From: [Holly Duncan](#)
To: [Jeff Watson](#)
Subject: RE: BL-11-00005 Schnebley
Date: Tuesday, February 22, 2011 3:01:25 PM

From: Jeff Watson
Sent: Tuesday, February 15, 2011 3:13 PM
To: Christina Wollman; Brenda Larsen; Jan Ollivier; Holly Duncan
Subject: BL-11-00005 Schnebley

Proposed 0.40 Acre Parcel

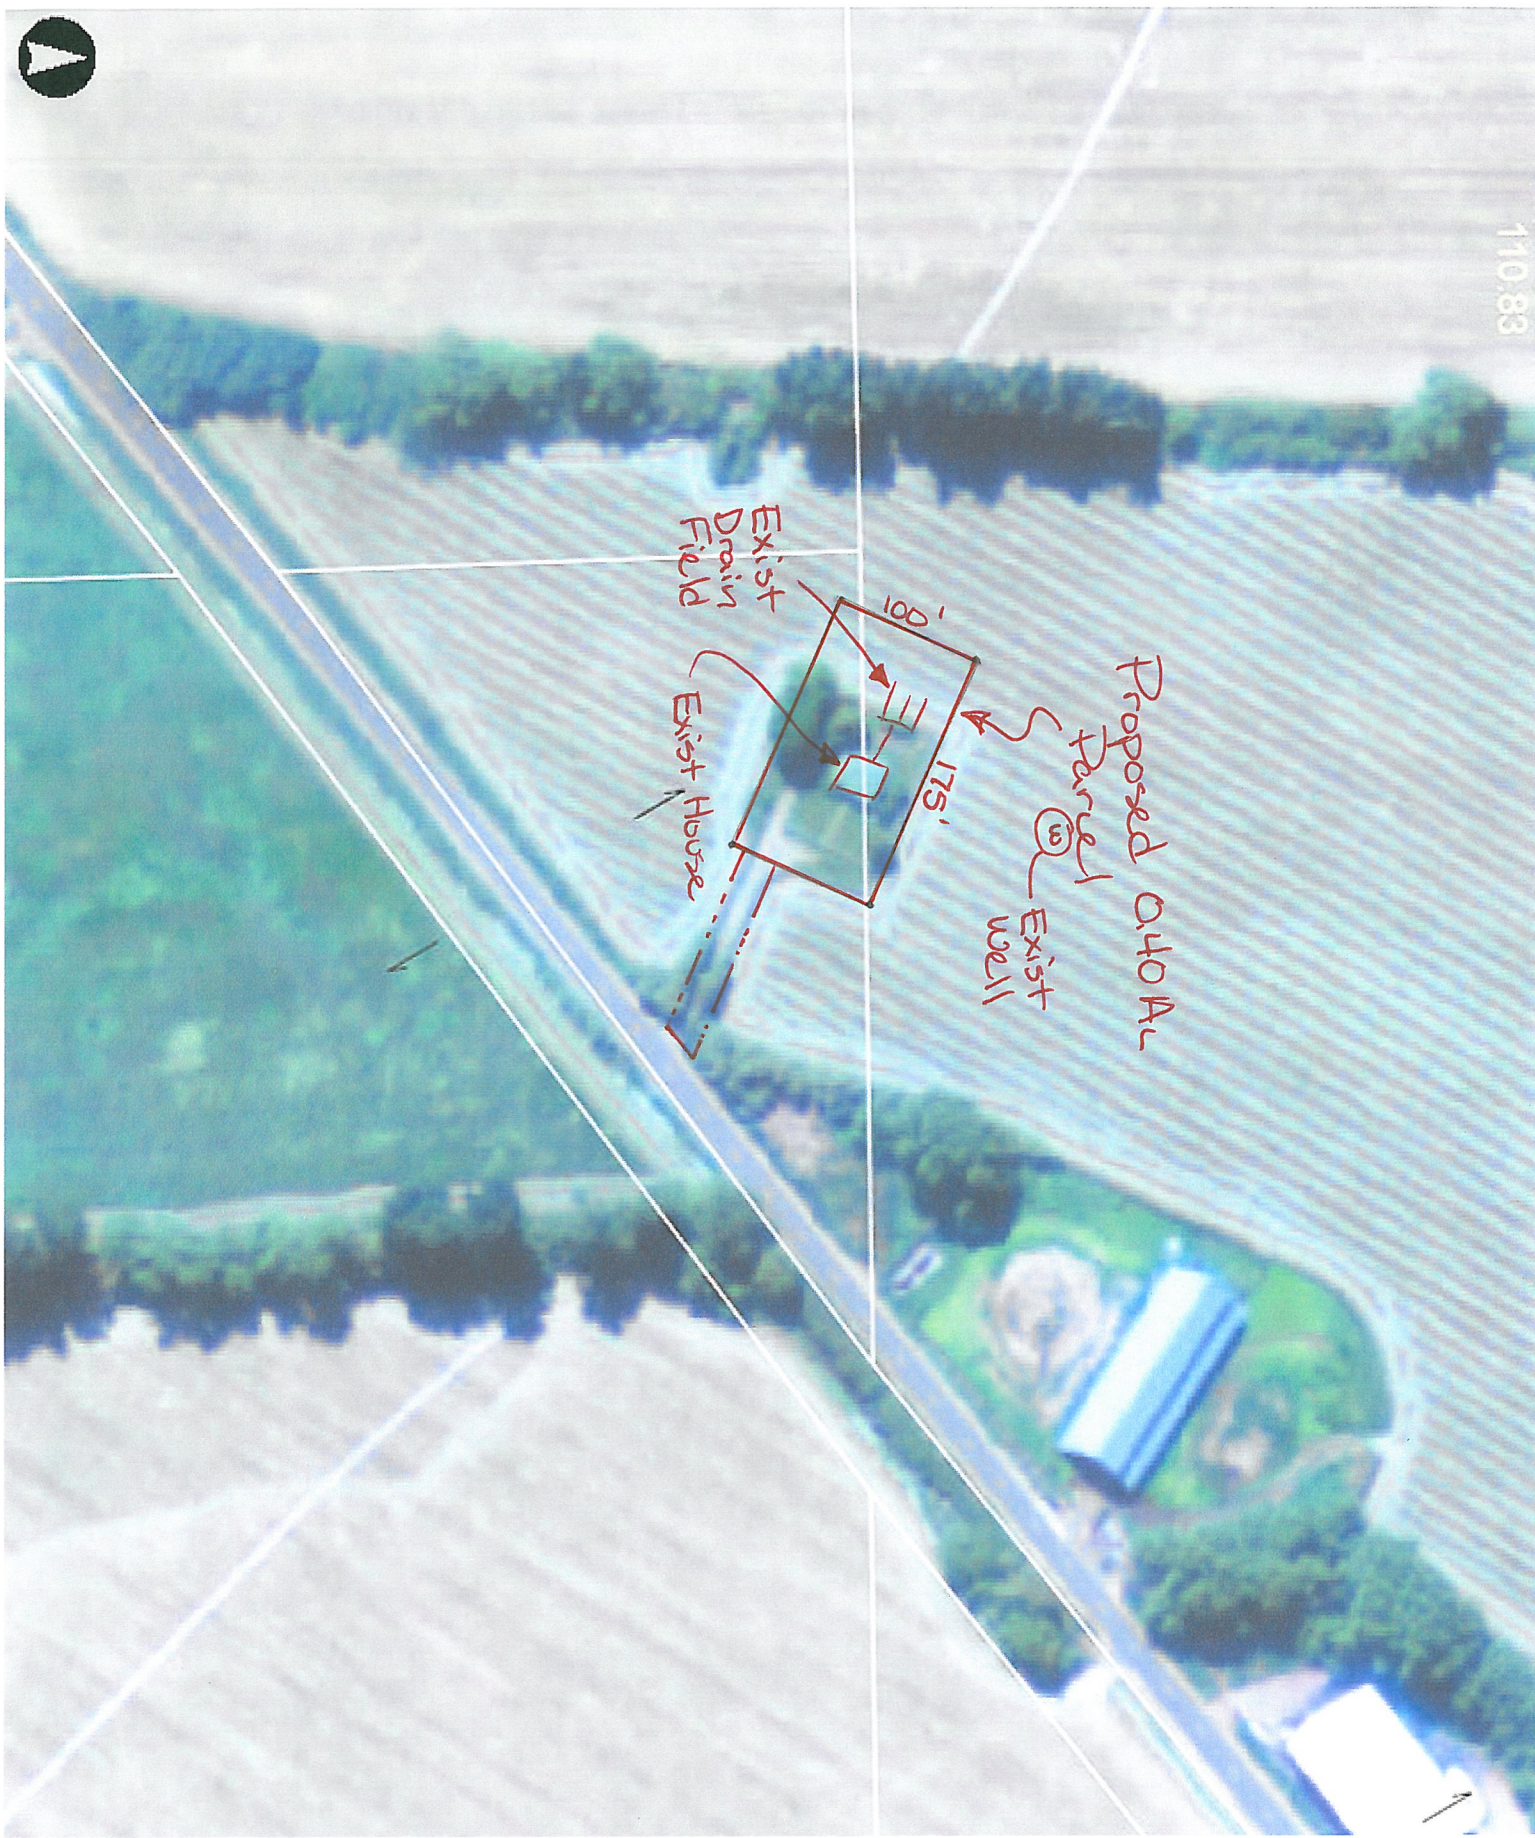
It appears that the well is over 50 feet from the property line in this one and that the on-site sewage system is within the proposed 0.40 acres. I see no issues with this one.
